**CITY OF PORTLAND, MAINE
DEVELOPMENT REVIEW APPLICATION
PLANNING DEPARTMENT PROCESSING FORM
DRC Copy**

2001-0288

8 Ledgewood Drive

Approval Conditions of DRC

**GRADING PLAN OF LAND
CITY OF PORTLAND
CUMBERLAND COUNTY
MAINE**

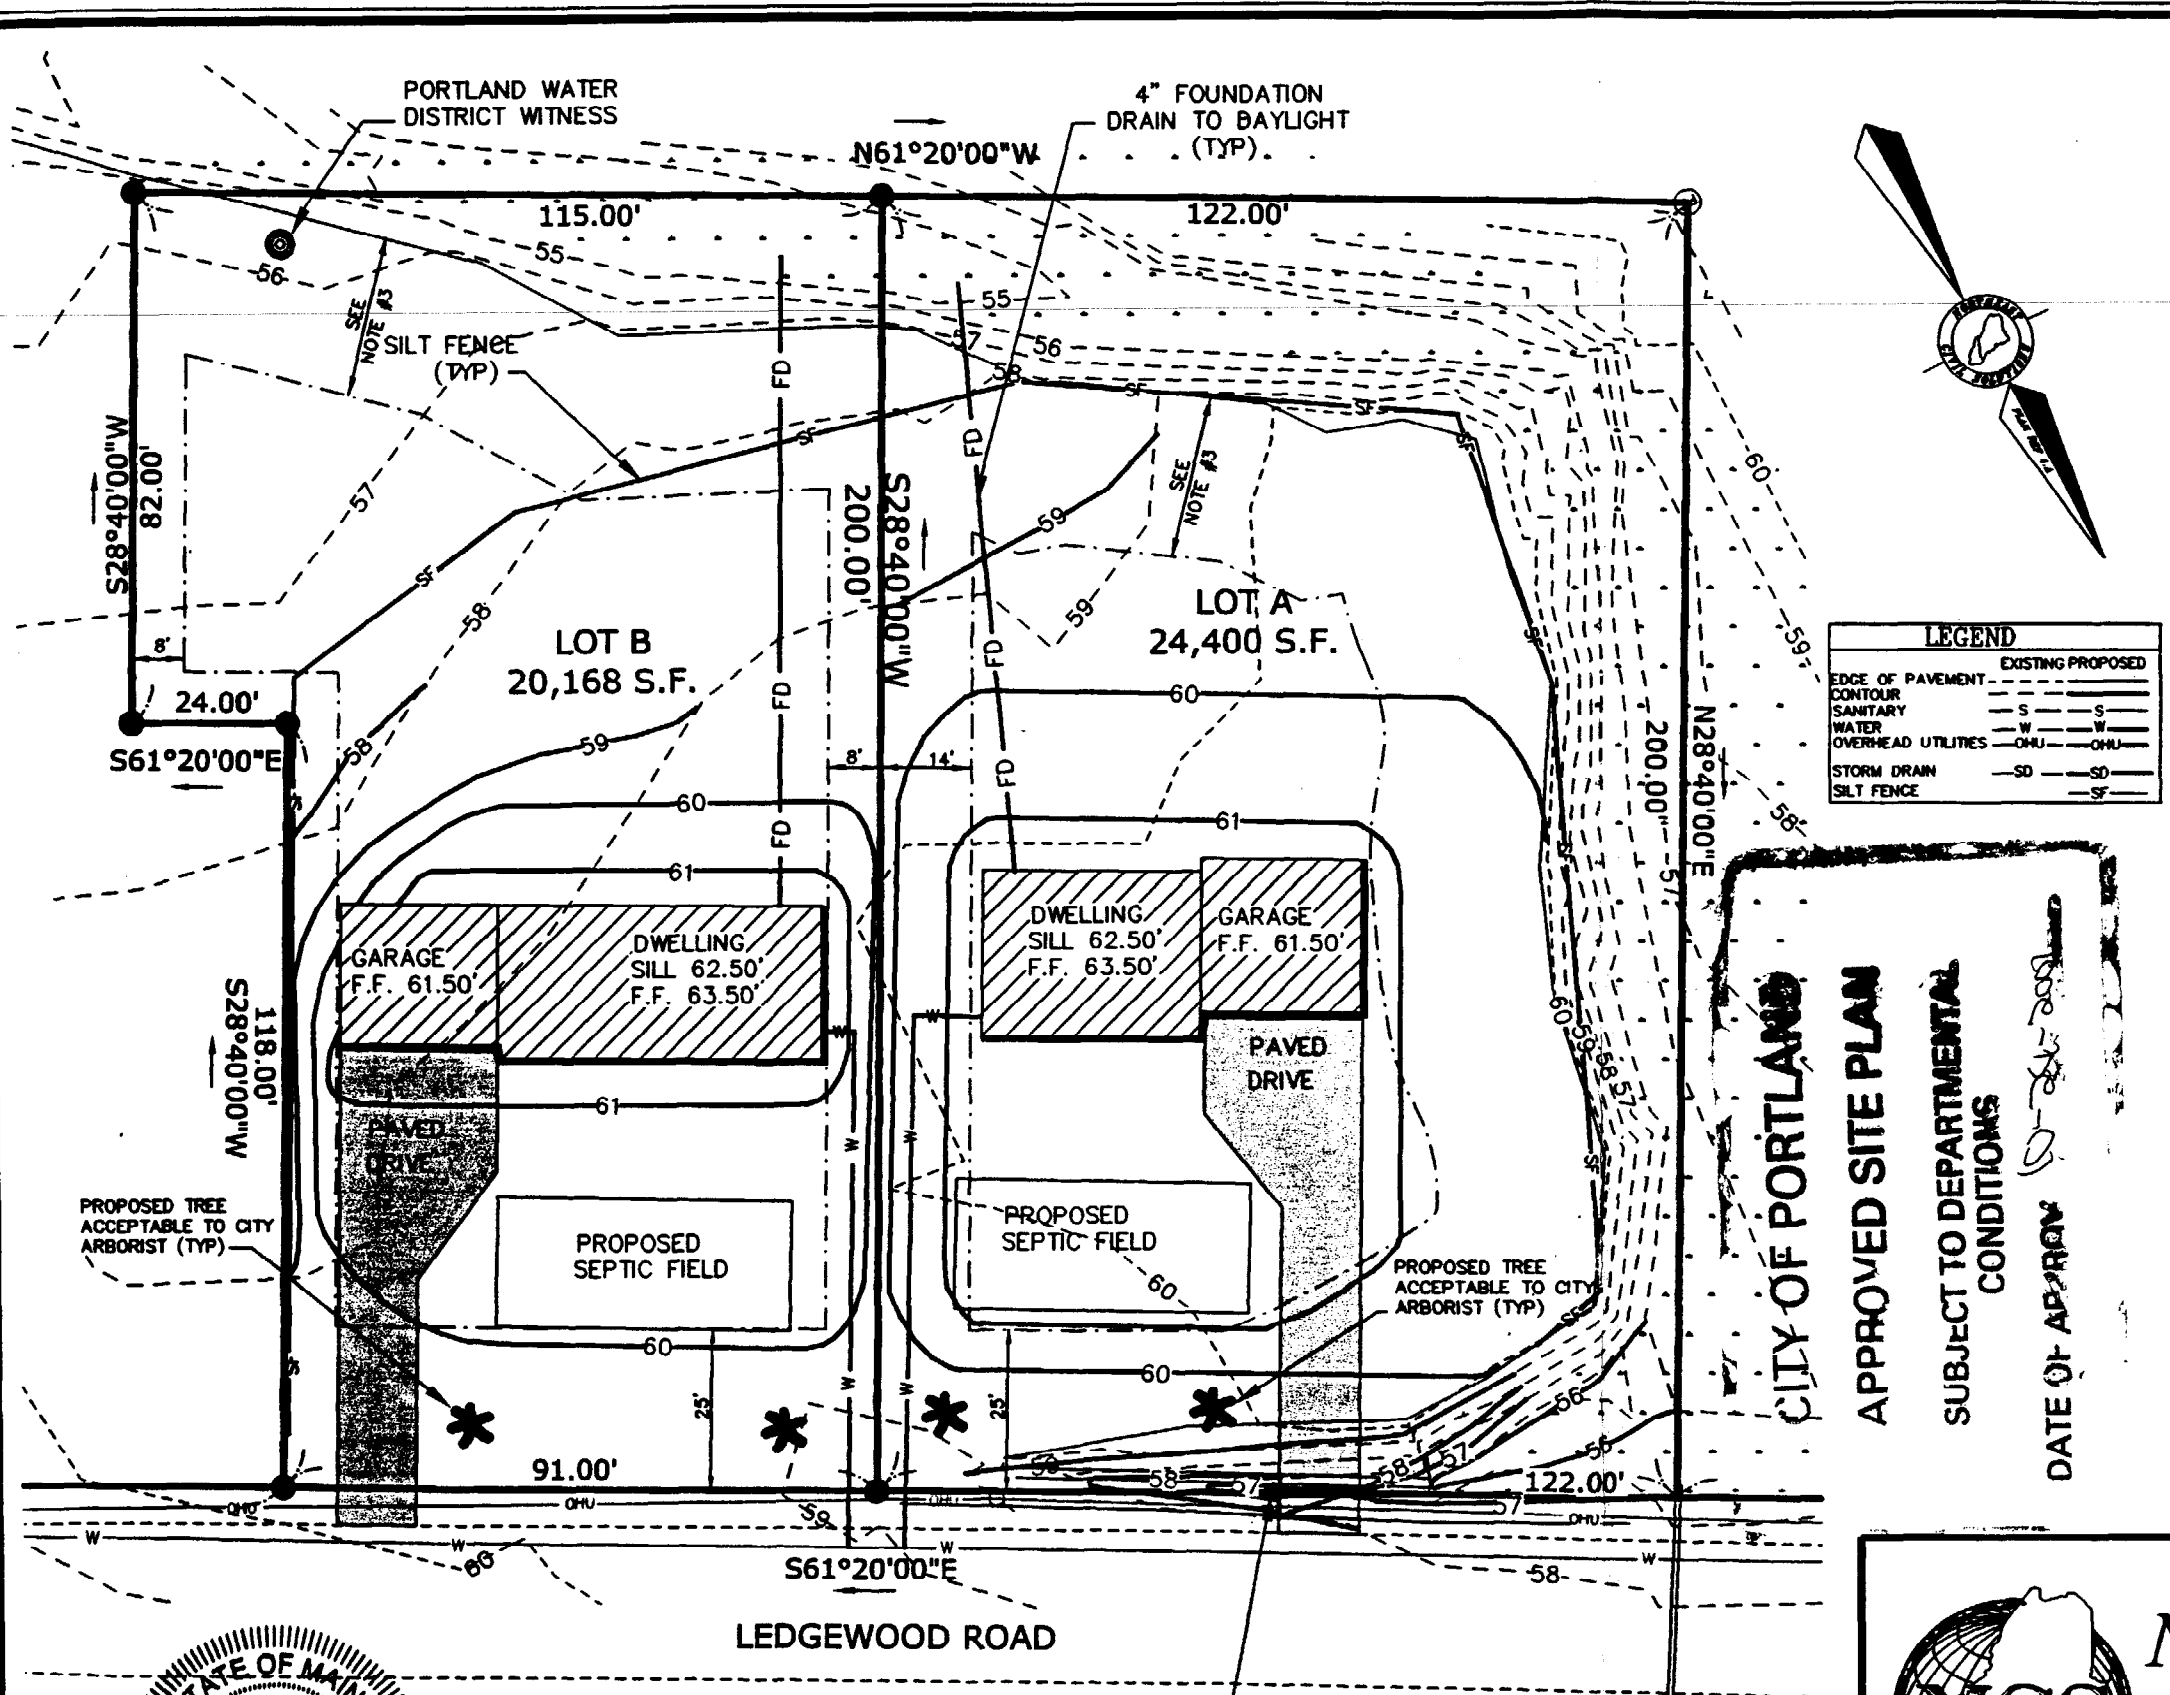
- 7 The site contractor shall establish finish grades at the foundation, bulkhead and basement windows to be in conformance with the first floor elevation (FFE) and sill elevation (SE) set by the building contractor to provide for positive drainage away from entire footprint of building.

- 8 The Development Review Coordinator reserves the right to require additional lot grading or other drainage improvements as necessary due to field conditions.
